Appeal Decision

Appeal Ref: APP/R5510/W/21/3281455

5 Nicholas Way, Northwood HA6 2TR

- The application sought planning permission for a Two storey, 4-bed dwelling with habitable roofspace, railings and gates, parking and amenity space involving demolition of existing dwelling without complying with a planning condition attached to planning permission Ref 2443/APP/2019/4085, dated 14 April 2020.

drawing no:	1326 / P / 2 ^F	drawn: FJ
-------------	---------------------------	-----------

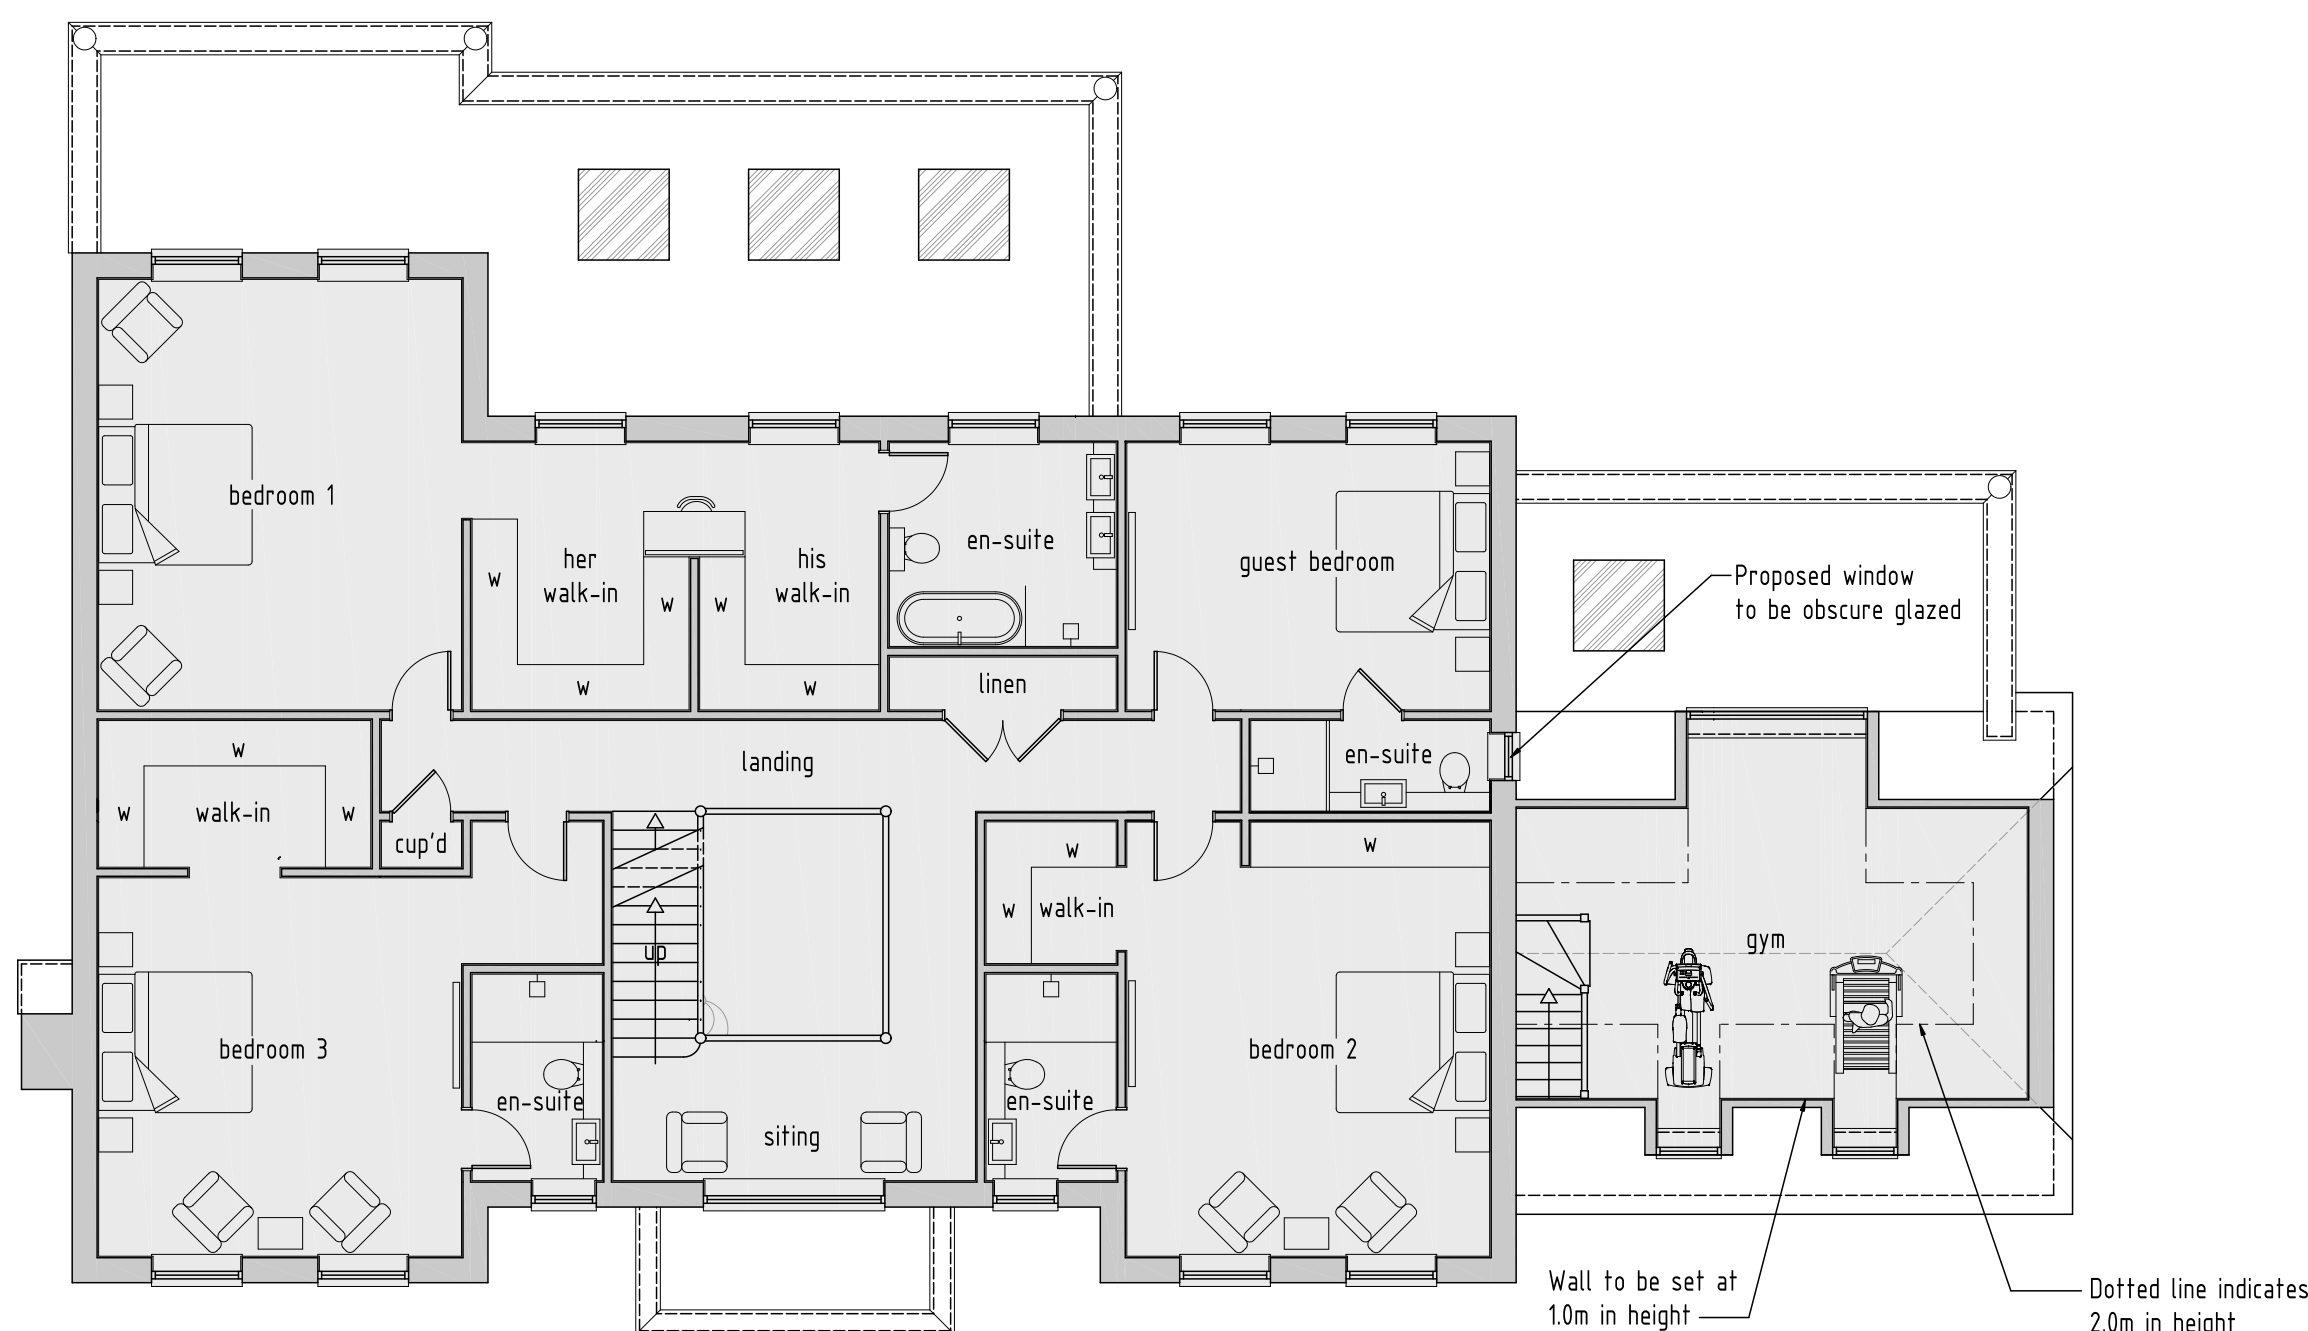
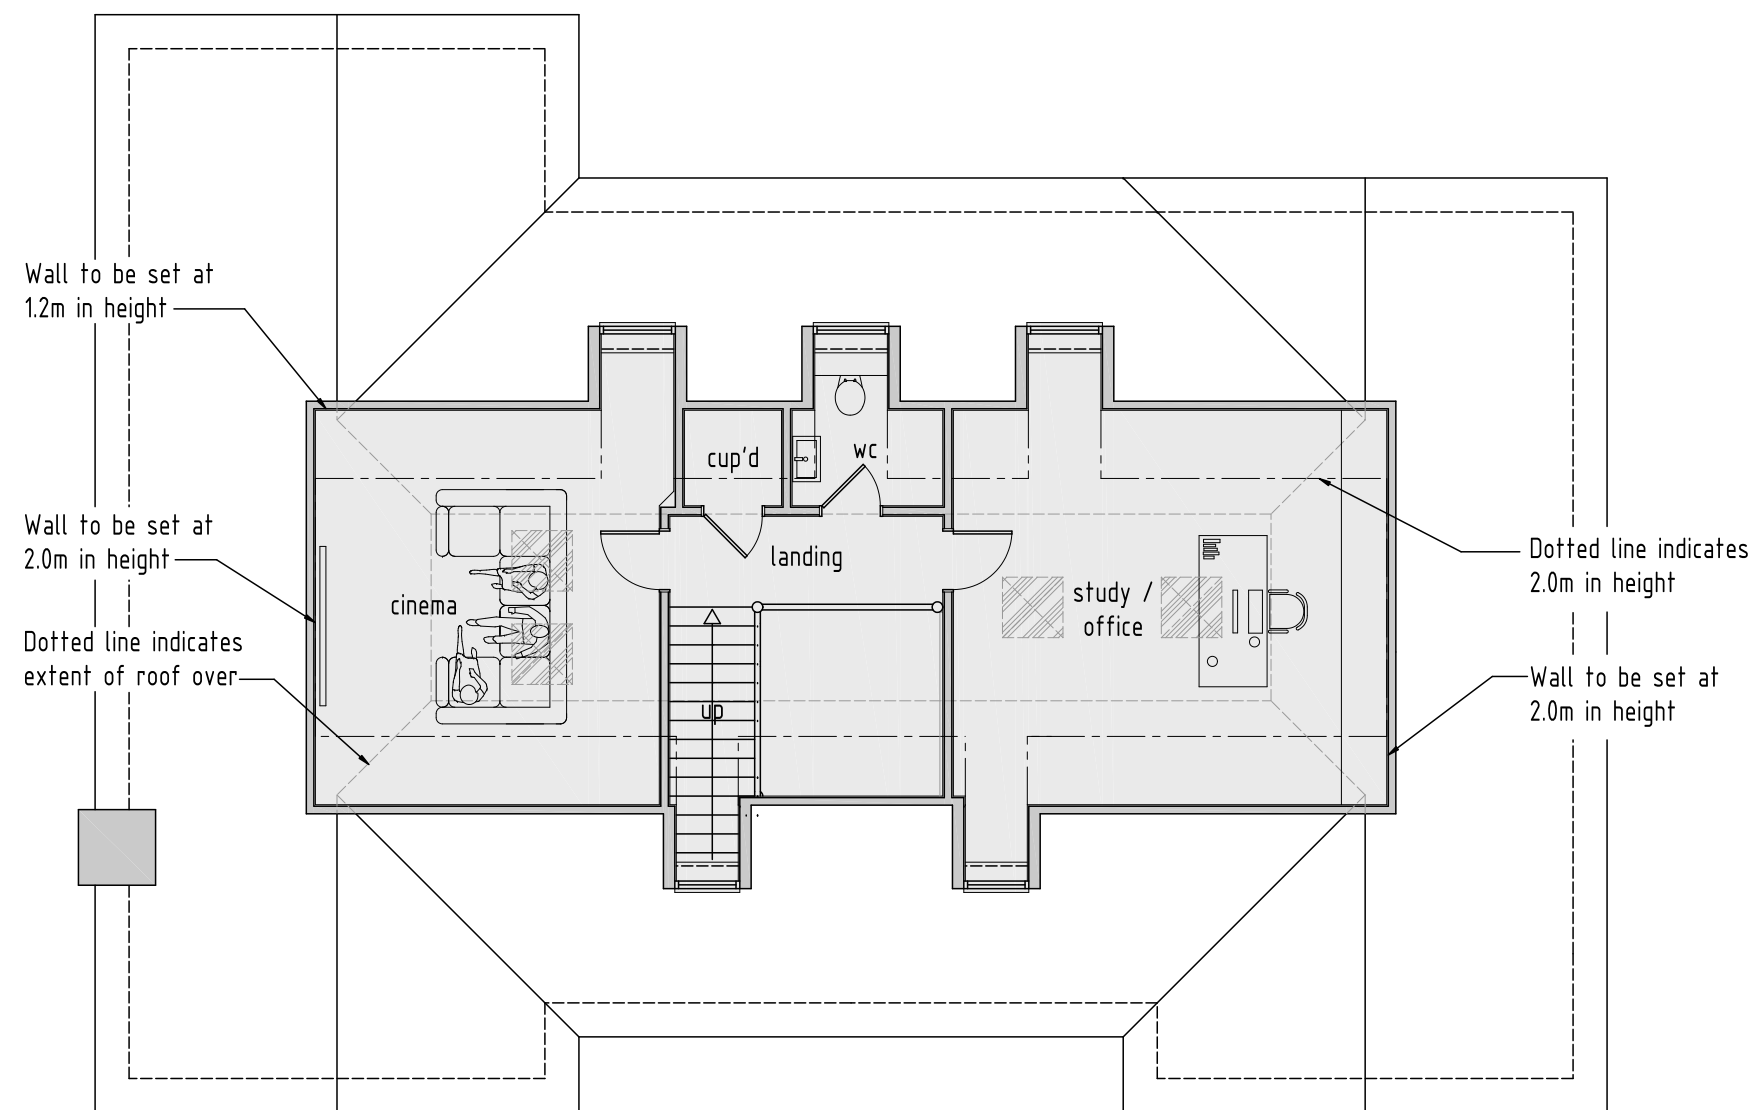
8. At the appeal site, the introduction of gable ends to the front roof-slopes of the projecting wings of the dwelling would add substantial bulk to the front of the property, which would be highly visible and therefore prominent within the street-scene, partly as a result of the limited set back that the property would have from the road.

9. This additional bulk would result in the dwelling forming an overly dominant feature within the street scene and would grant it an appearance and character which would contrast markedly with other dwellings at the northern end of Nicholas Way.

10. The proposal would therefore be detrimental to the character and appearance of the area and the ASLC. It would therefore conflict with policies BE1 and HE1 of the Hillingdon Local Plan Part 1 Strategic Policies (2012), policies DMHB 1, DMHB 5, DMHB 6, DMHB 11 and DMHB 12 of the Local Plan Part 2 Development Management Policies (2020) and policies D3 and D4 of the London Plan (2021) (LP).
